Application ref: AB/113/25/AOO

Description: Application to approve First Schedule Clause 4 (Public Open Space Specification) in the Section 106 dated 26.11.21 (as amended) in relation to planning permission AB/135/20/OUT

Location: Land at Ford Road Arundel

Summary recommendation: This submission has not provided suitable information to satisfy the AOO requirement for Play provision.

DRAWING NO: Q8969_E

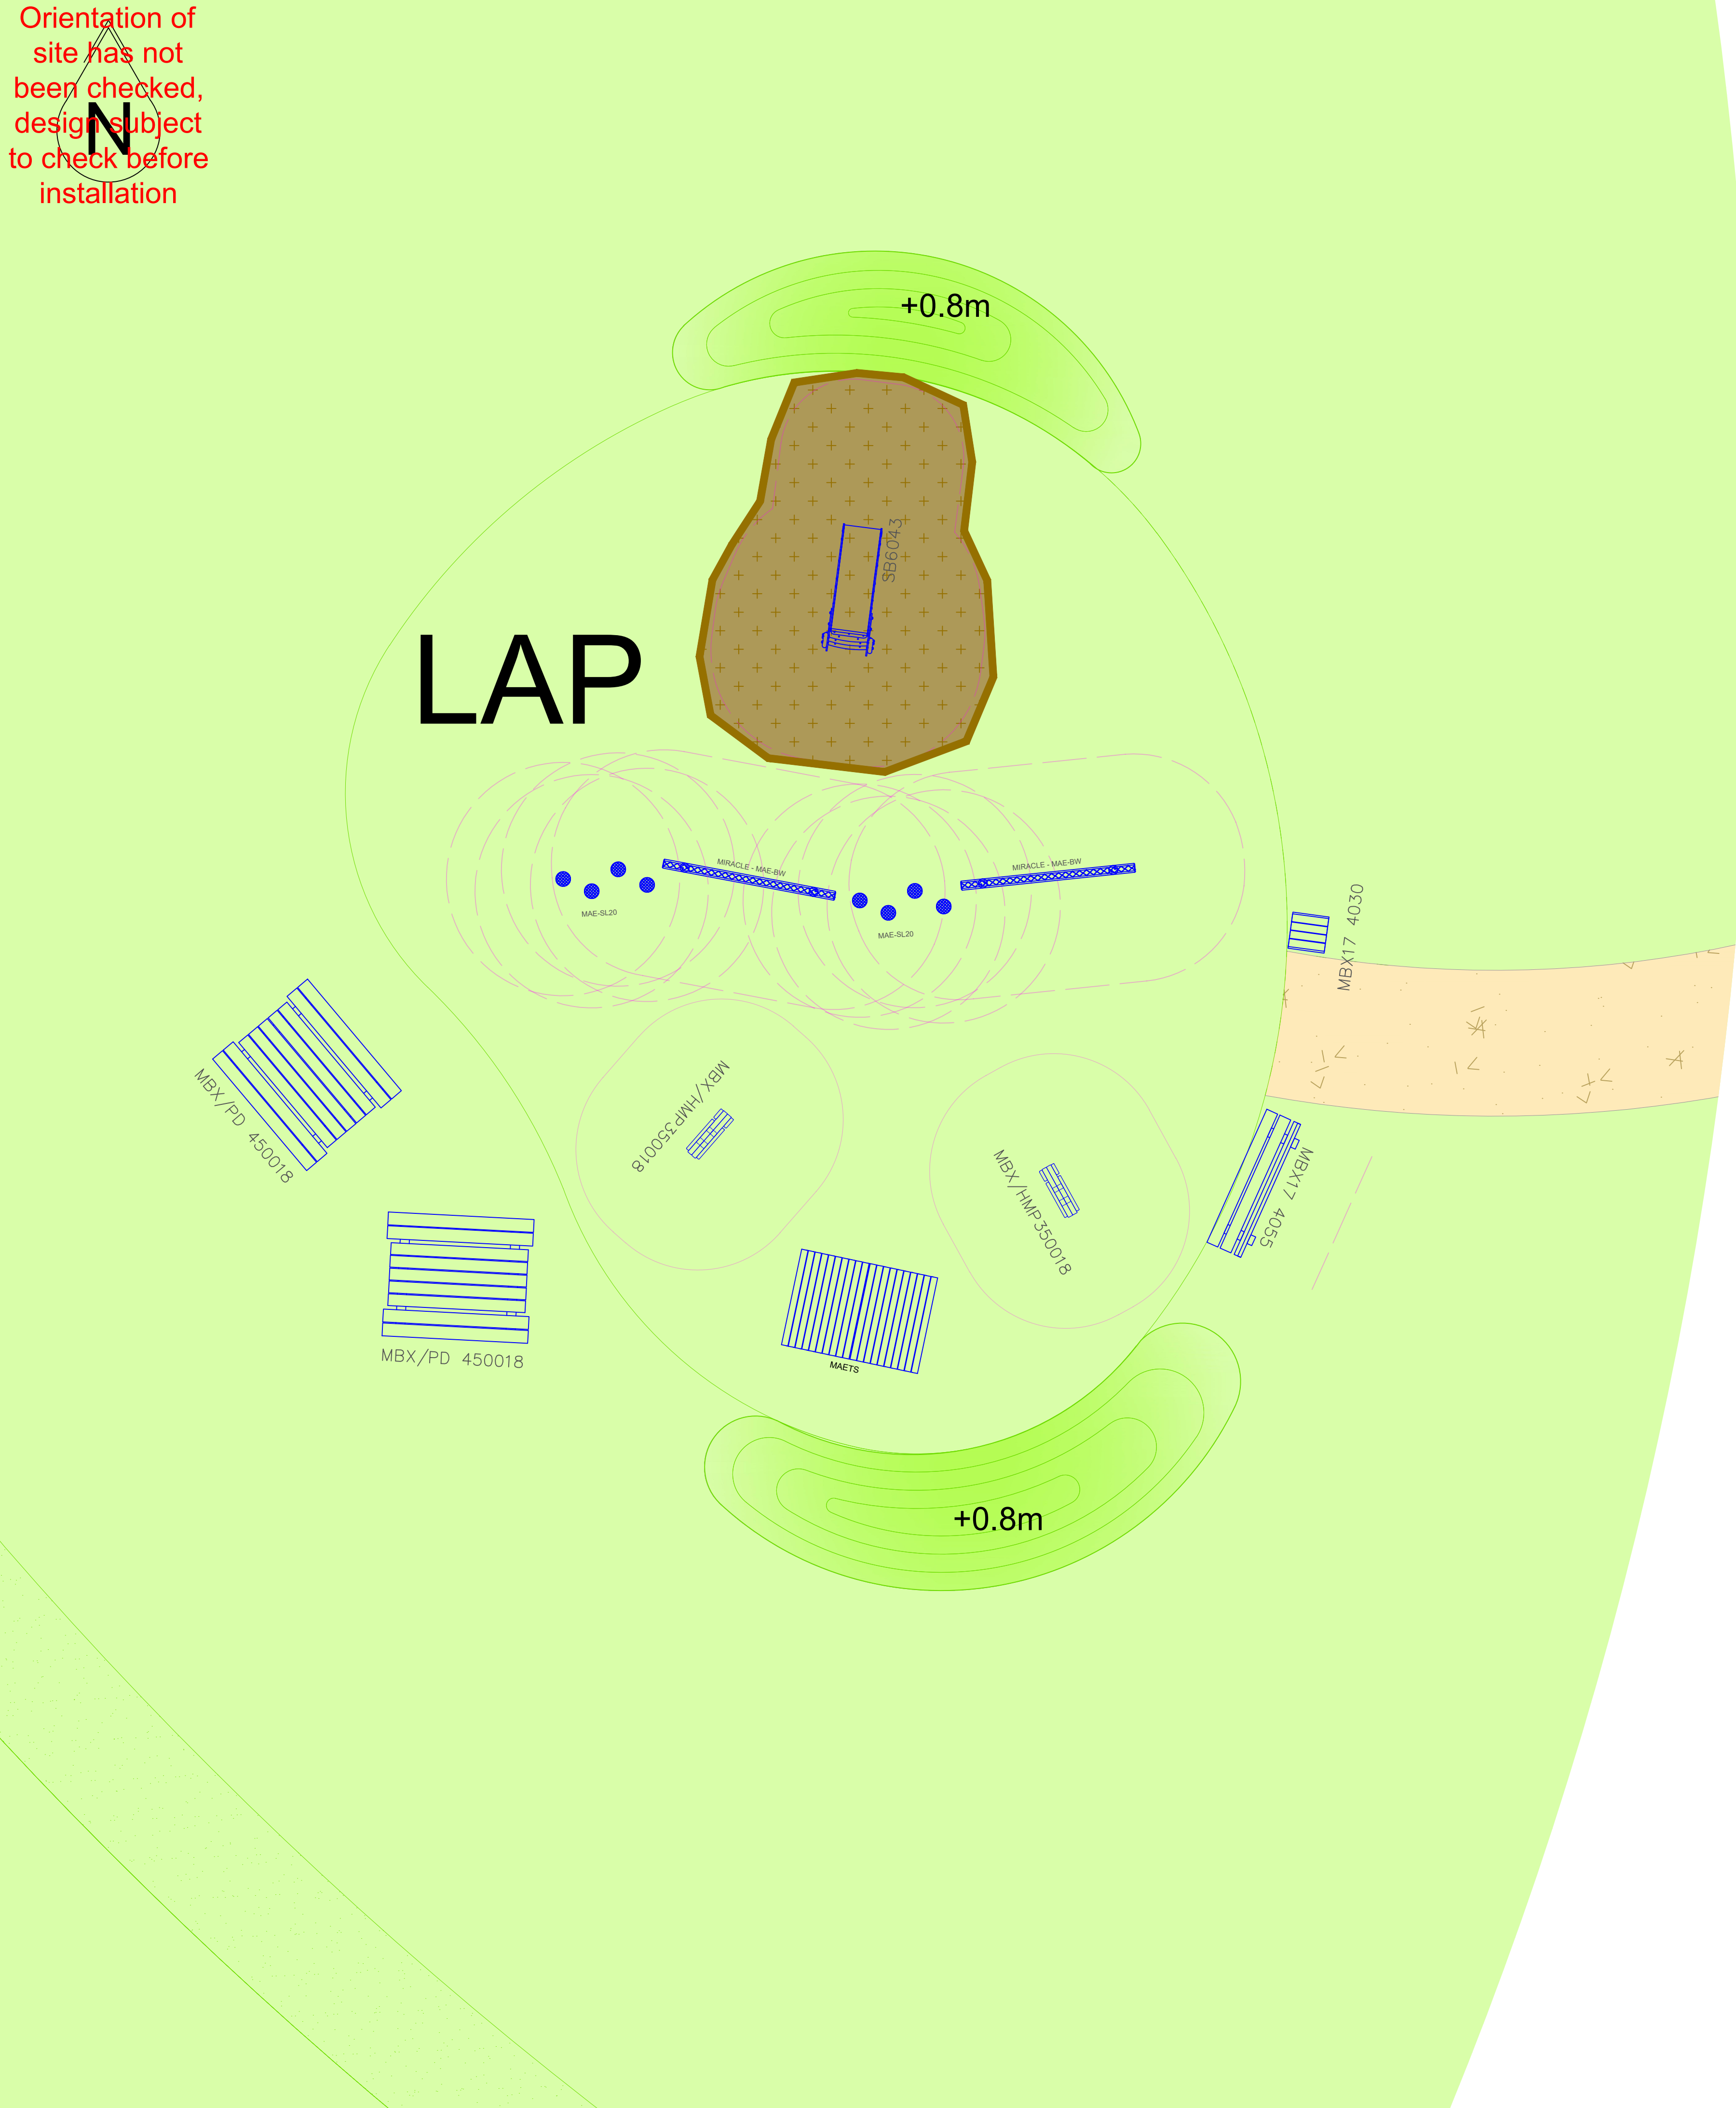
- Dwg 09.09.25 LAP AREA Q8969 - C and Dwg 09.09.25 LAP Q8969 – C provides detail of LAP 1 which has been amended to omit the swing and now contain slide provision. No detail of LAP surround/enclosure has been provided. Rubber crumb surfacing has been indicated to the slide area, but no other wear surfacing ie rubber matting is shown to any other play pieces (not required for critical fall heights, however confirm surfacing in these areas). The slide has no connection in the landscape and appears at odds with the area – grass mounding is shown adjacent to the slide which would be better utilised incorporating the slide into the mound. The LAP appears to sit in a desert landscape with no trees or planting to soften the area and create setting. The LAP does not integrate well into the landscape or portray a welcoming or quality offer which would be expected from the emerging development.
